Planning and Assessment Division
Department of Planning, Industry and Environment

Bobs Farm Sand Mine Project – SSD 6395

Thank you for the request for advice from Public Authority Consultation (PAE-14928719), requesting the review by the NSW Environment Protection Authority (EPA) of the Response to Submissions – (RtS), for the proposed Bobs Farm Sand Mine Project (Application SSD 6395) at Bobs Farm, in the Port Stephens Council Local Government area.

1. Location N1- 776 Marsh Road

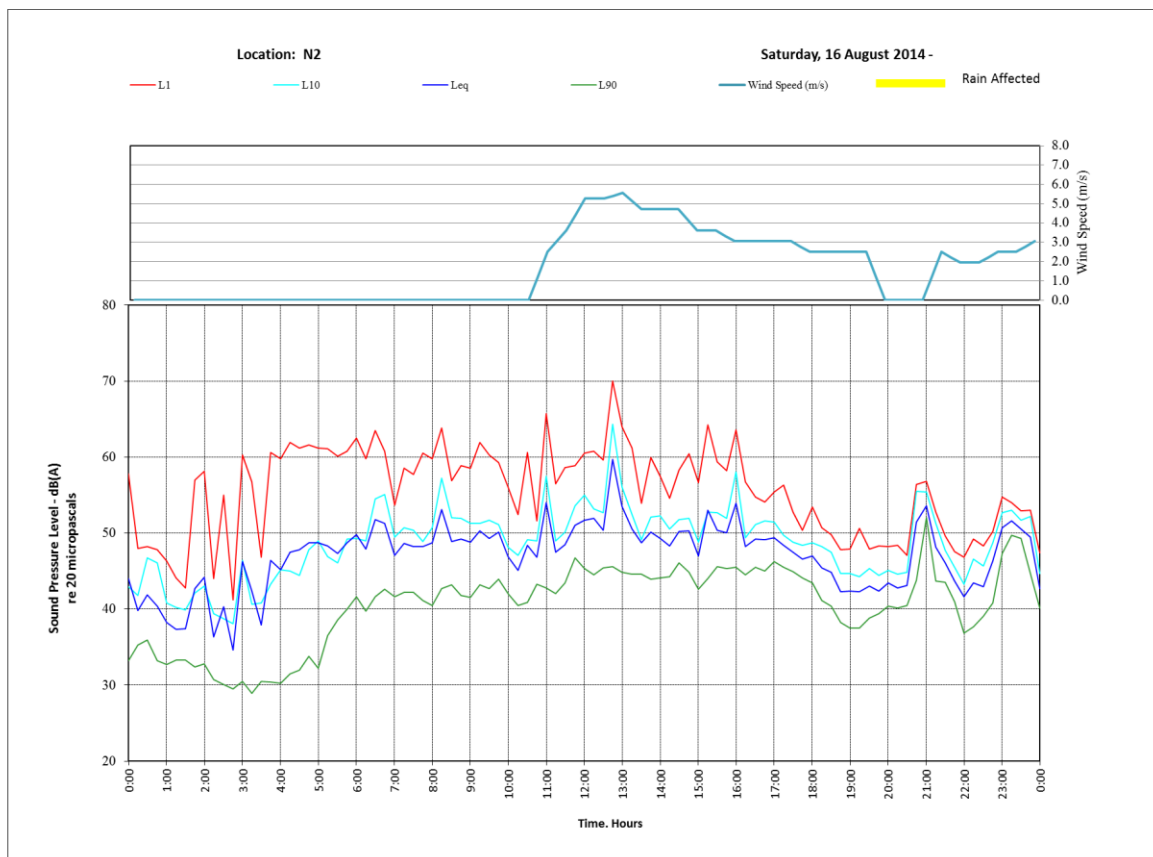
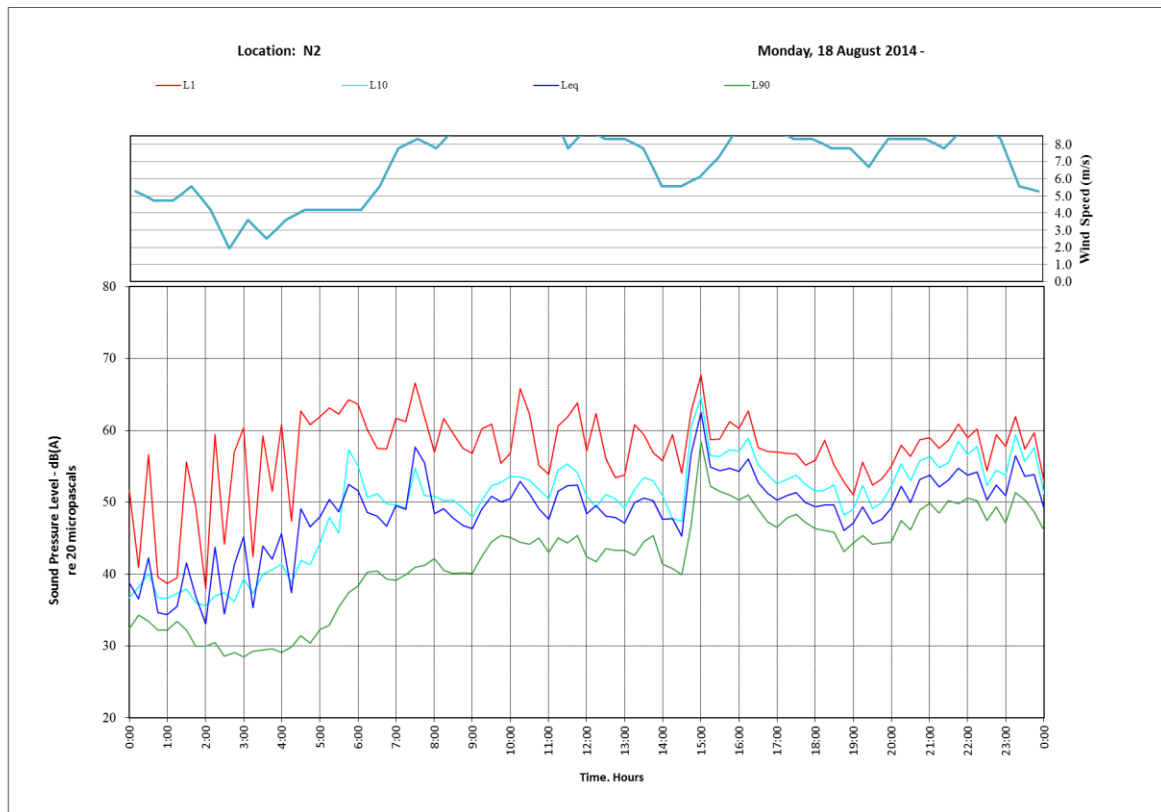
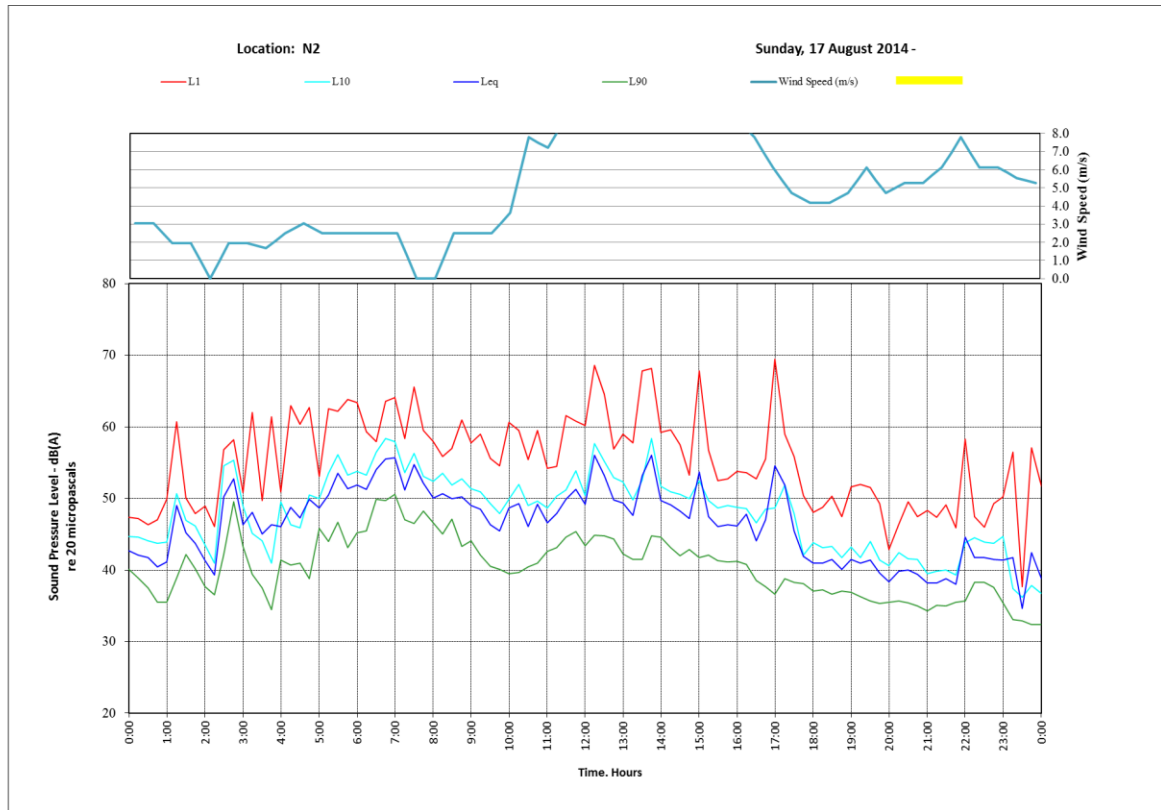
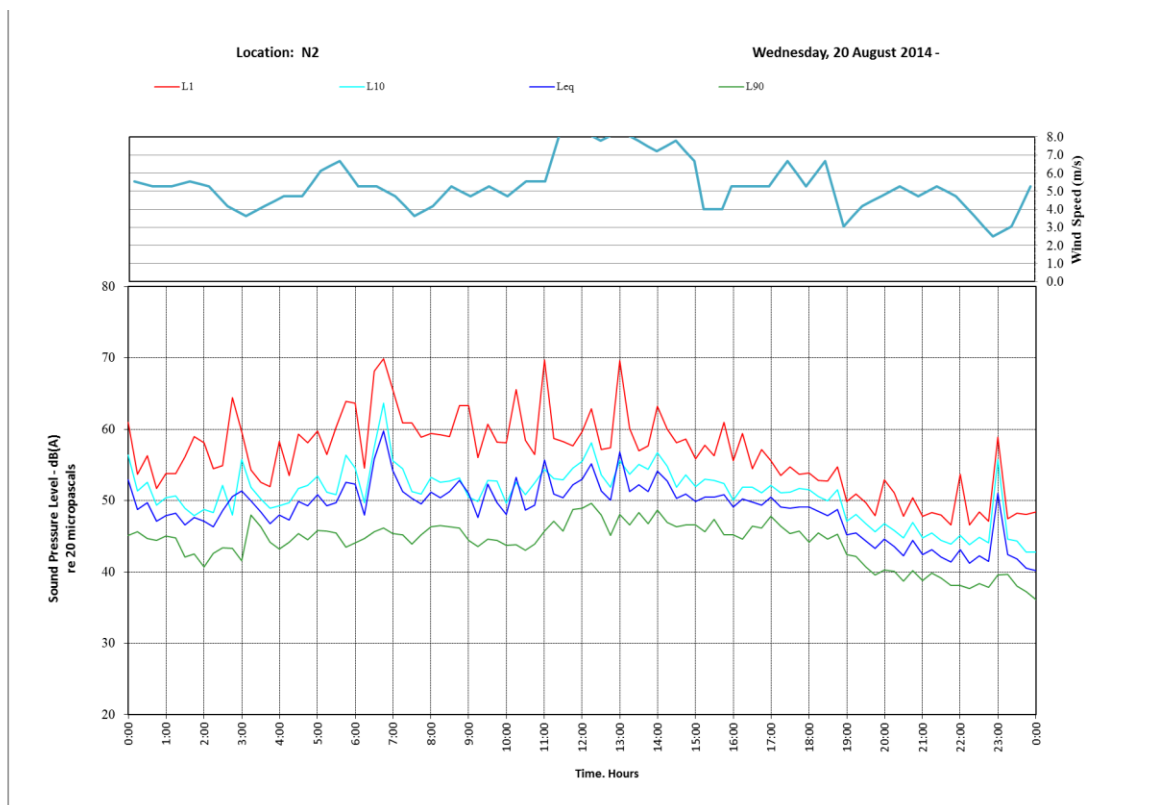
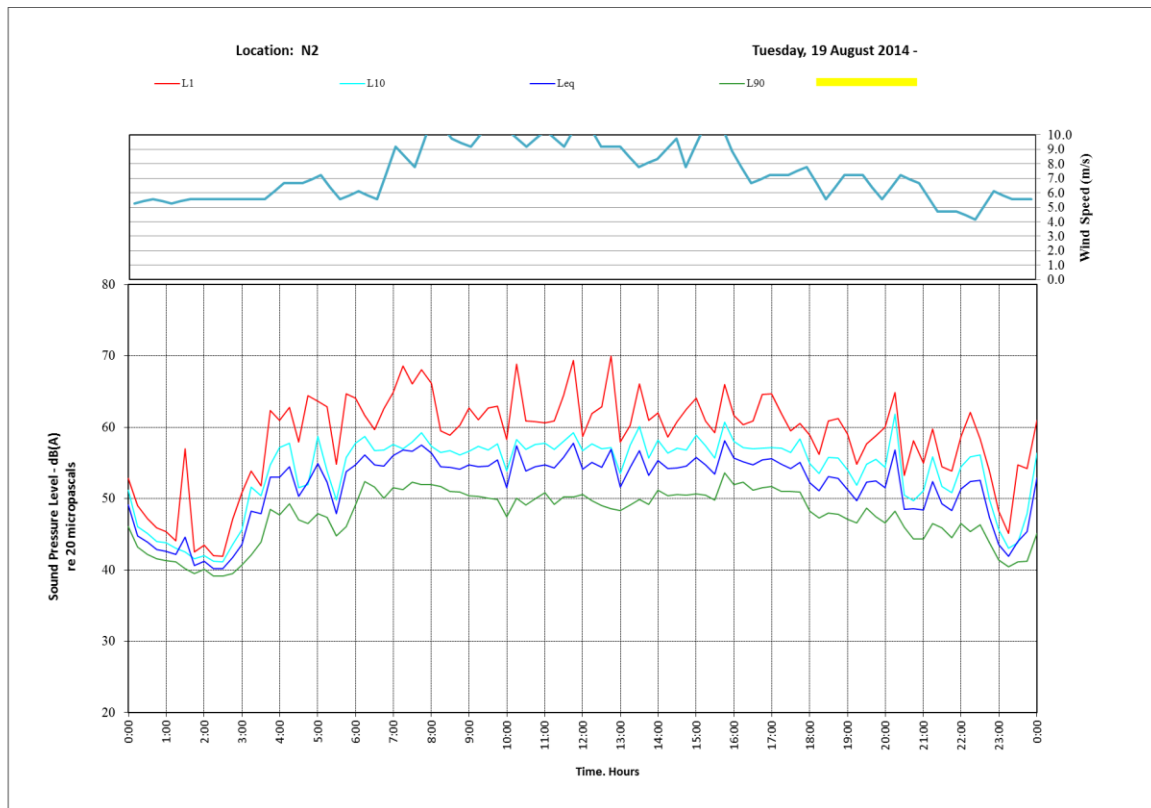
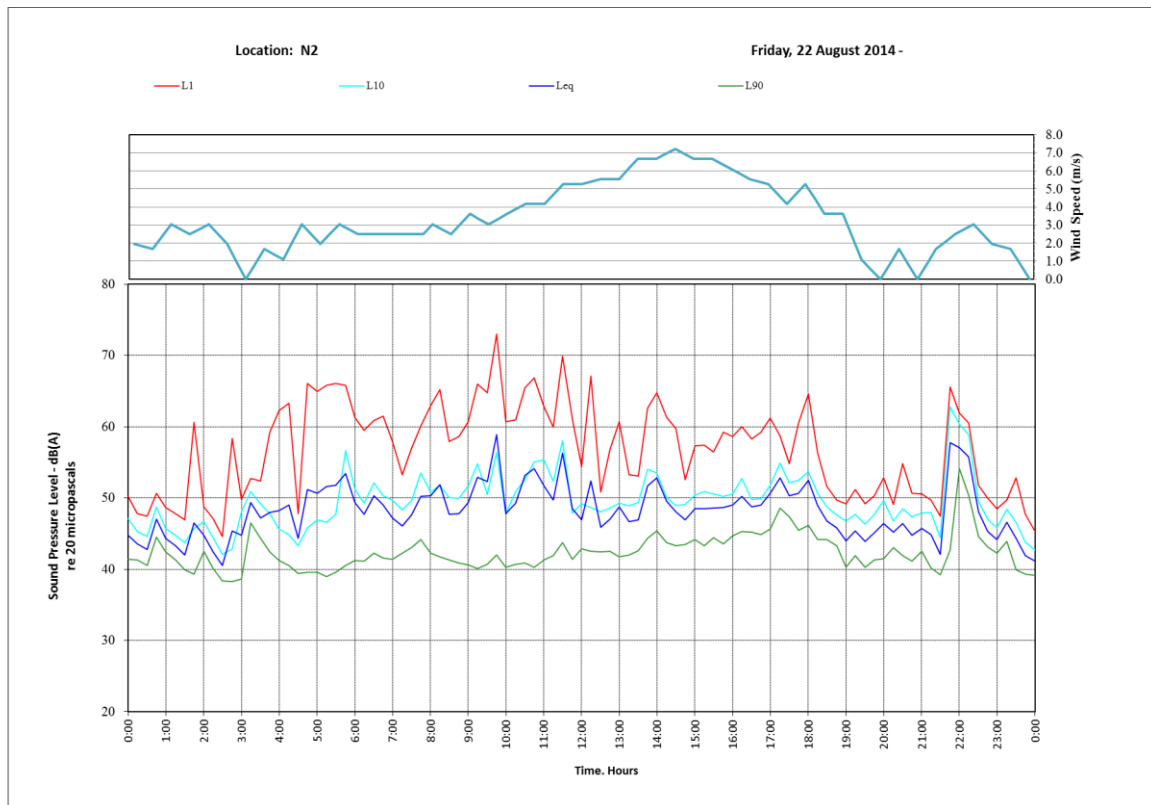
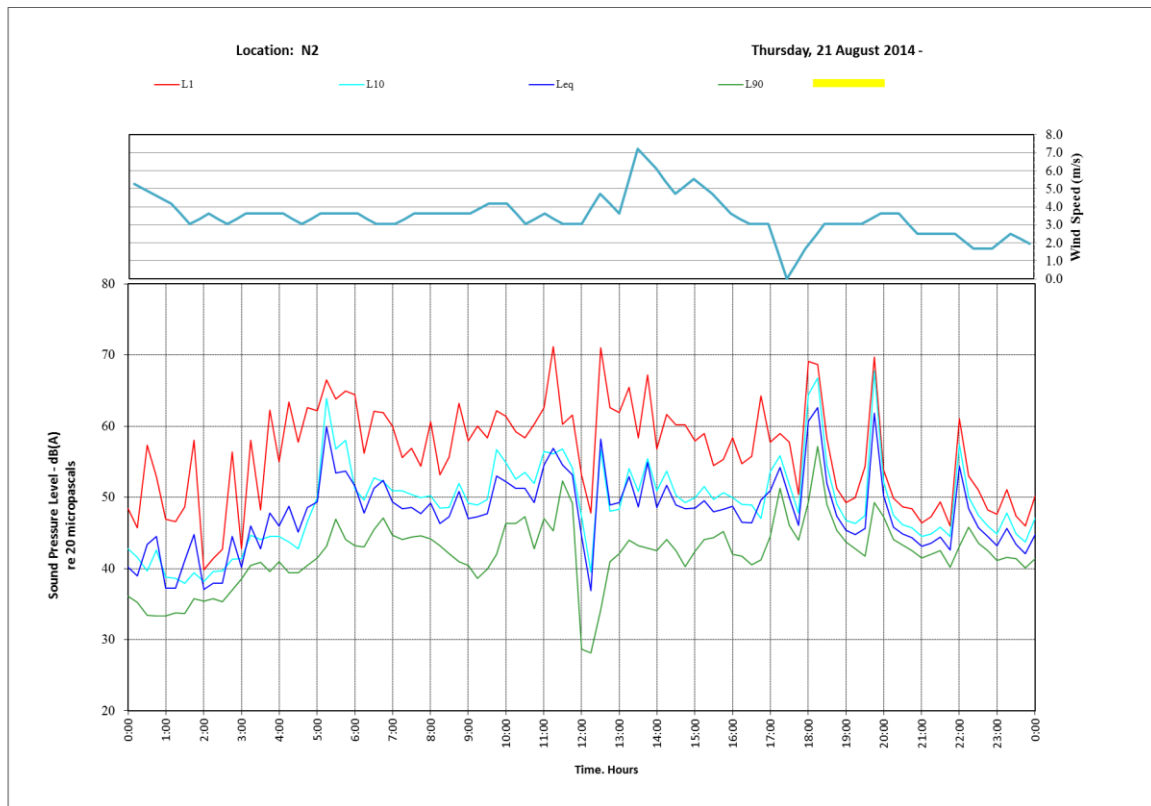
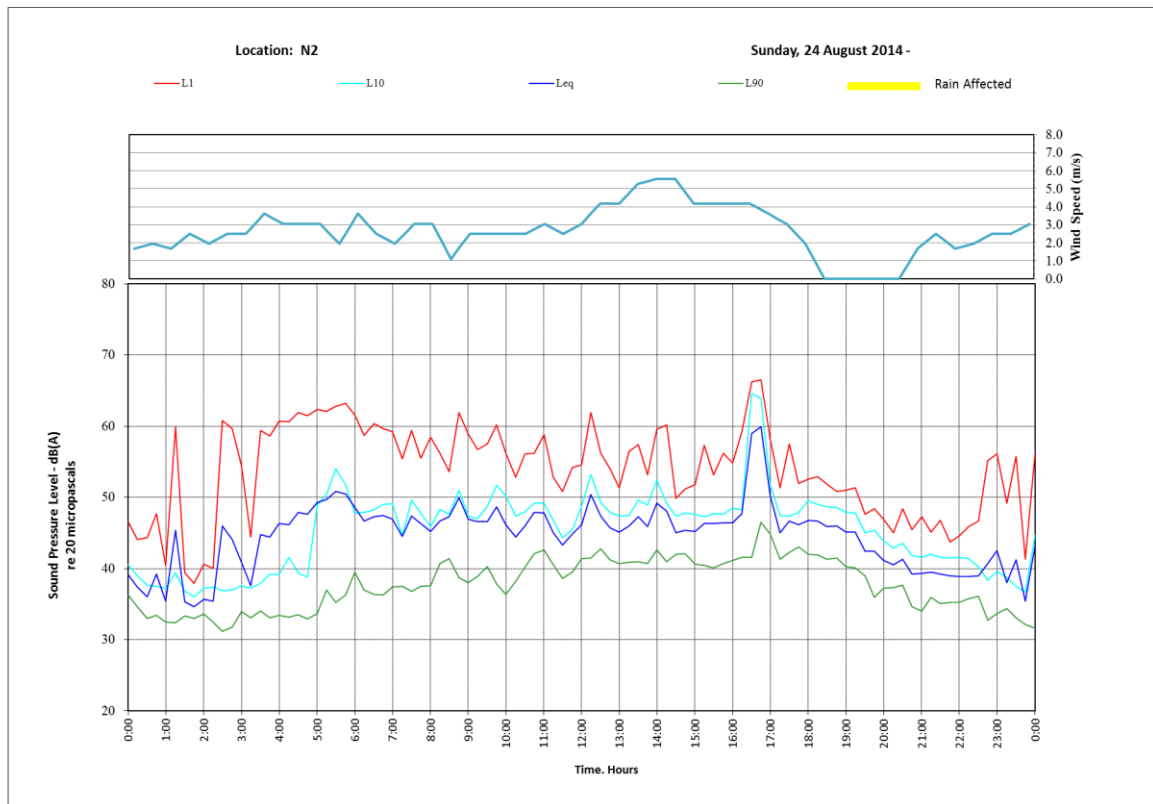
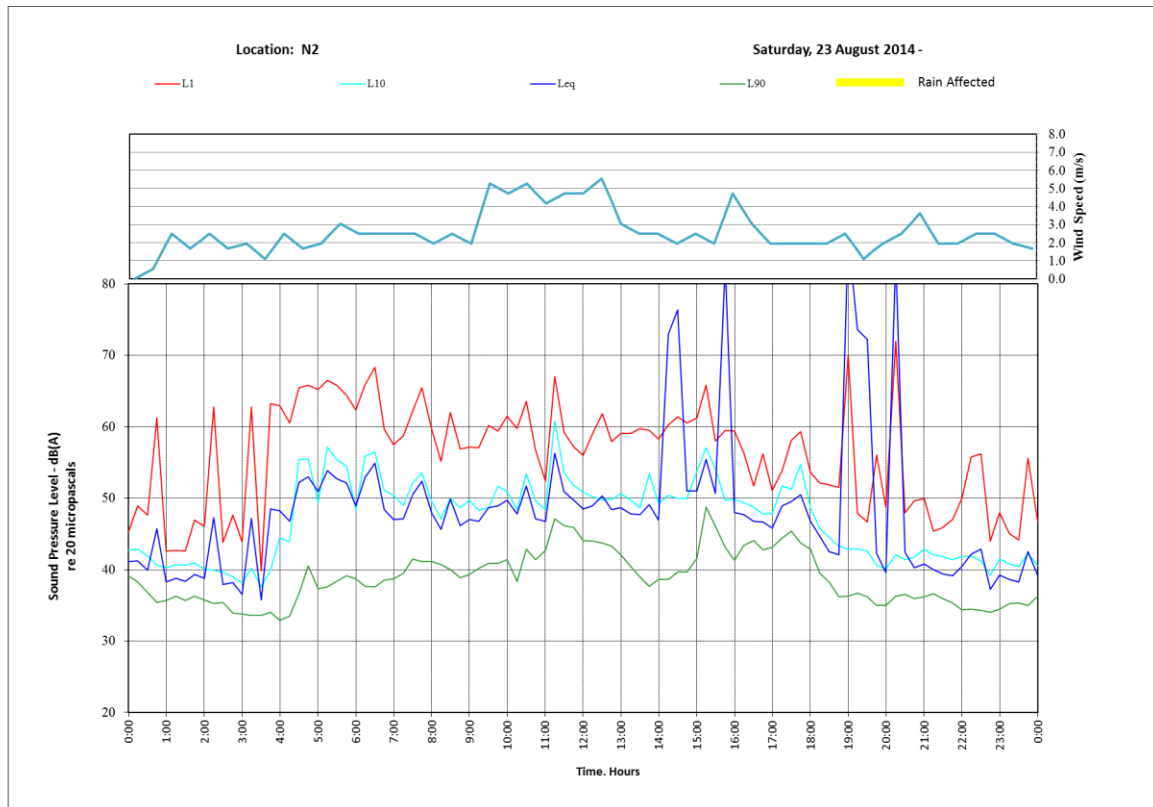
1. Table 4-2 of the UNIS shows a summary of current ambient noise levels. Both 'LA90' and 'RBL' are listed for each monitoring location. The proponent should clarify the meaning of the 'LA90' value for each time period, and how it is distinct from the RBL value.
2. At location N1 for the evening period, the RBL is 42 dBA, which is higher than both the daytime RBL of 35 dBA and the night-time RBL of 28 dBA. As the monitoring was carried out in October, and from the elevated noise level traces in the logger charts of Appendix B, The EPA considers the evening RBL may be influenced by seasonal fauna/insects and may be lower than this value during other times of the year.

The proponent should adopt a RBL value of 35 dBA for the evening period at N1 (in line with the daytime RBL value, and in accordance with the guidance in Section 2.3 of the Noise Policy for Industry), or alternatively provide adequate justification and evidence that the evening RBL value at N1 was not influenced by noise from seasonal fauna.
